Ann Machado - Re: 4 Adams St., Peaks Island - permit #2014-02164

I have completed my initial zoning review.

A.1

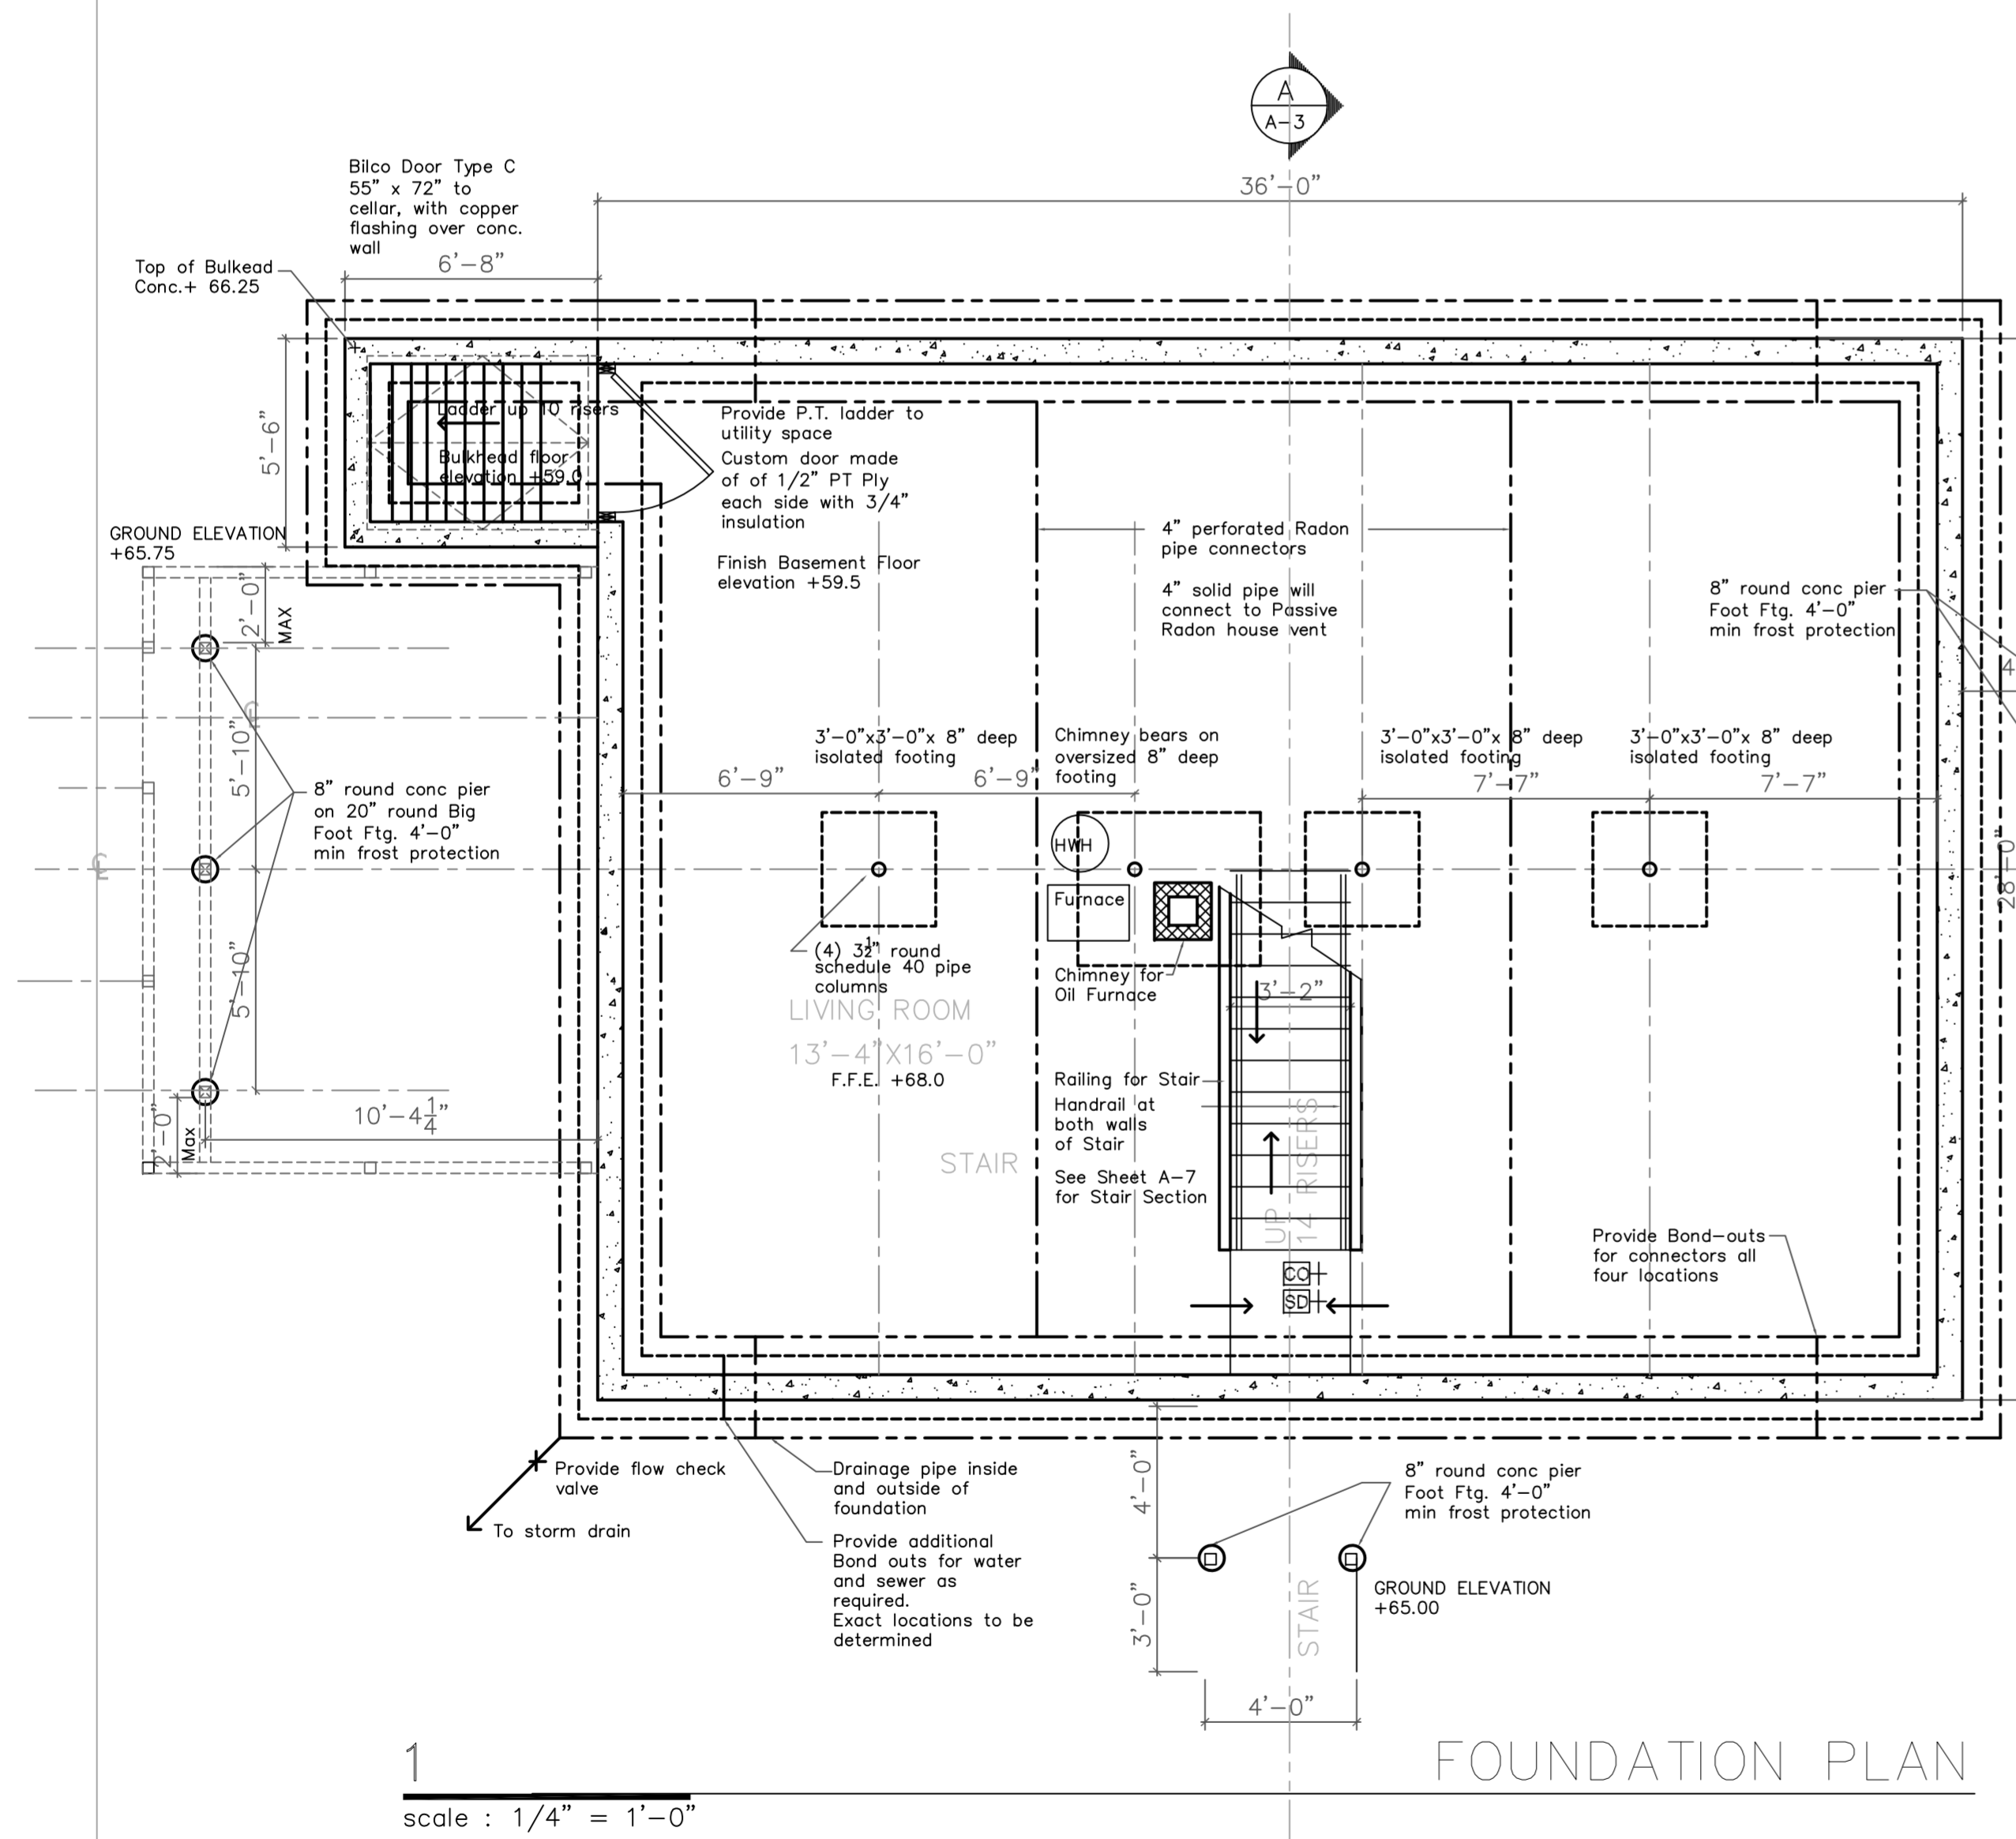
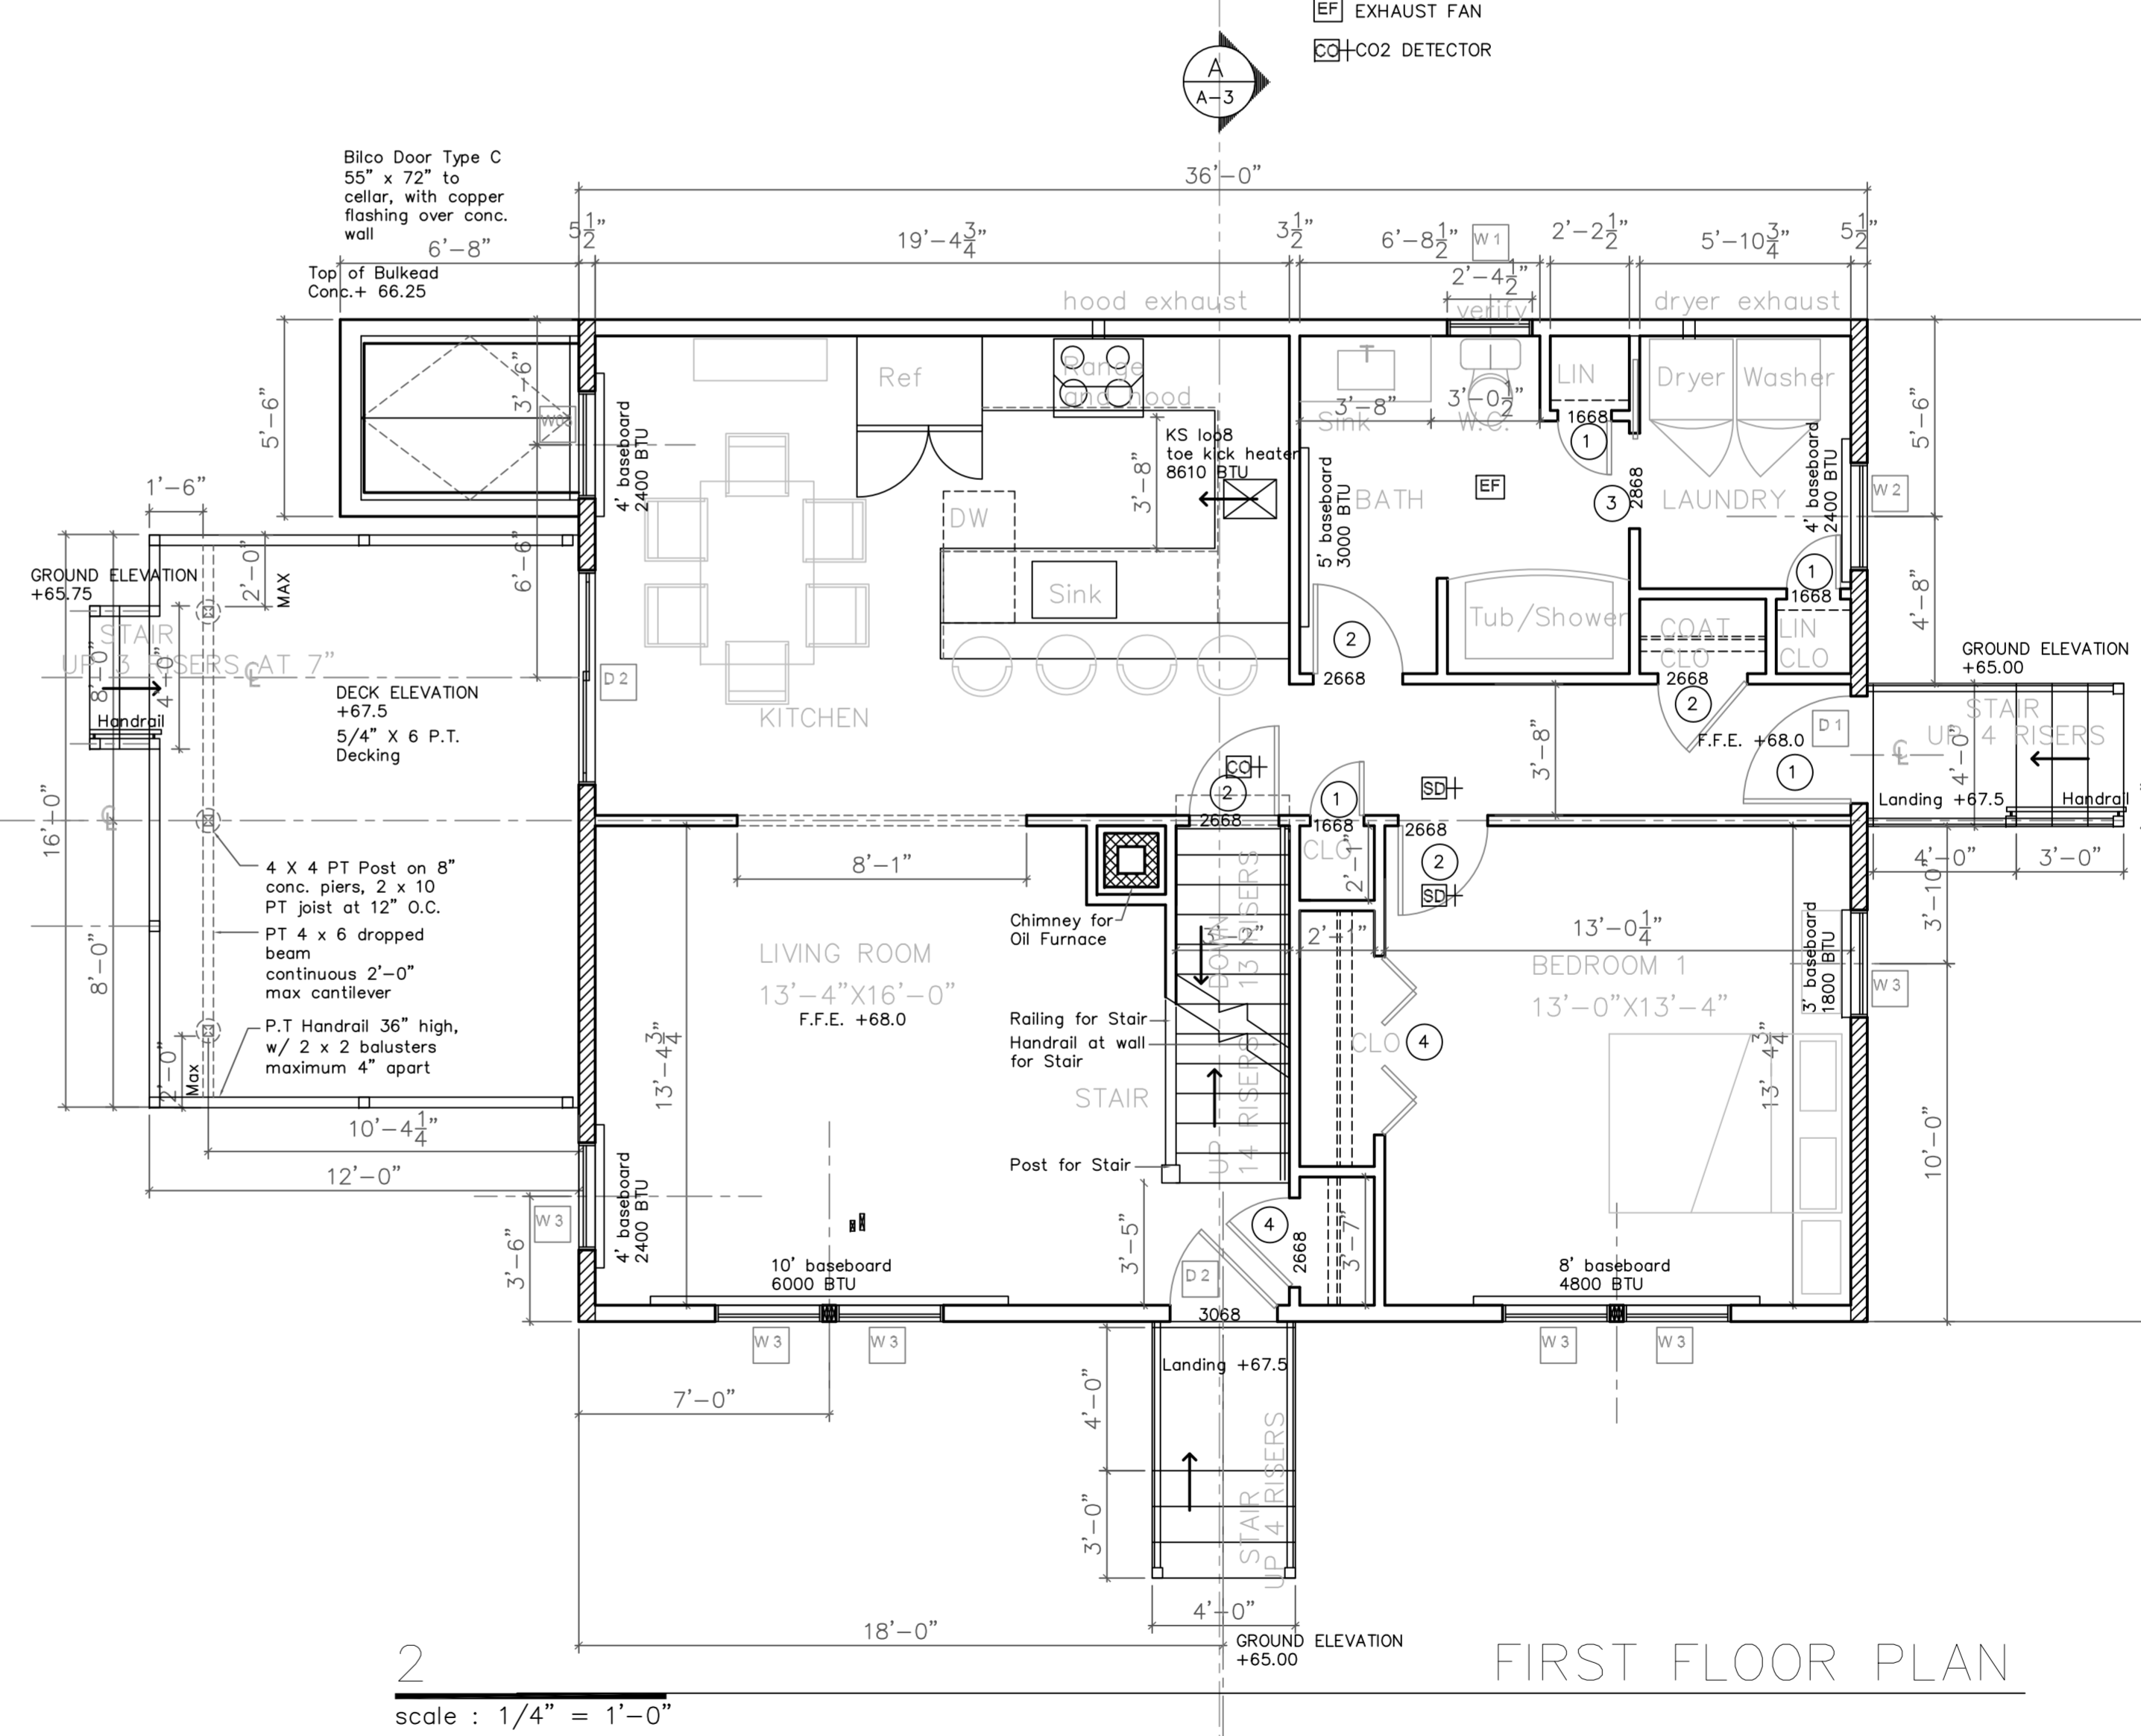
First of all, this permit does not fit the fast track application category. You checked New Sprinklered One & Two Family Homes as a category. You can only use this if all the plans bear the seal of a licensed design professional. All the plans need bear the license; A1 Proposed Exterior Elevations and A2 Proposed floor Plans do not bear a seal. It will need to go through the regular review process.

Second, on Plan A2 Proposed Floor Plans, it says "Future Second Floor". Is the second floor not being built out as part of this permit?

Regarding A2: We thought it would make it easier to review, but since it has caused questions, we would like to withdraw it from our submission packet. You will find that it is identical to S3, which does have the engineer's stamp on it.

"Future Second Floor" Plans: We are planning on having an unfinished second floor - the framing, electrical and roughed-in plumbing will be done. There will be no sheet rock, flooring or finish work completed, but the sprinklers and heat will be installed.
